Our ref: OUT22/3195

13 April 2022

Subject: **Daroobalgie Solar Farm (SSD-10387) – Environmental Impact Statement (EIS)**

Figure 3-1 Existing Site topography and drainage features at the solar farm site

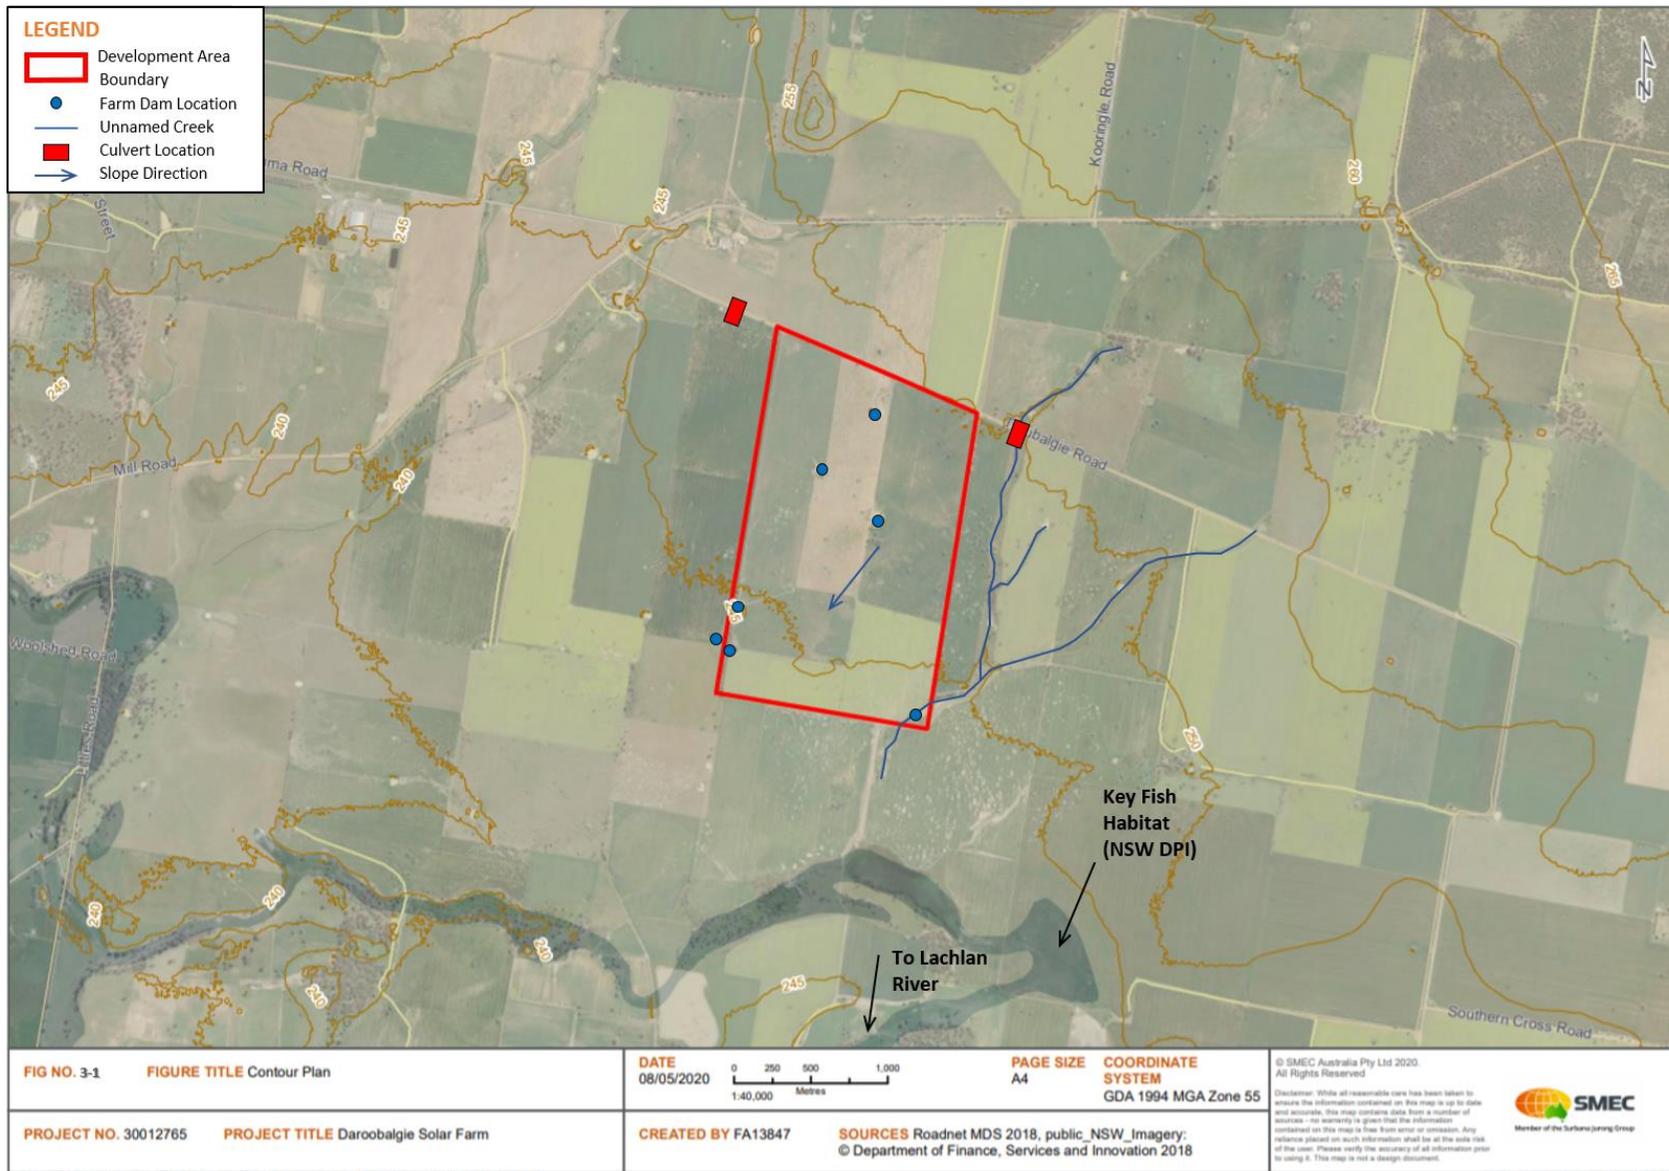
- Clarify the number and location of dams which are to be retained and removed by the project.
- Confirm the availability of an appropriately authorised water supply to meet the construction requirements. Should additional water supply works or water entitlement be required, this needs to be clearly identified and assessed for impacts and the ability to acquire entitlement.

Conflicting information has been provided between the Main EIS report and Appendix G which state four dams will be retained and three are to be retained respectively.
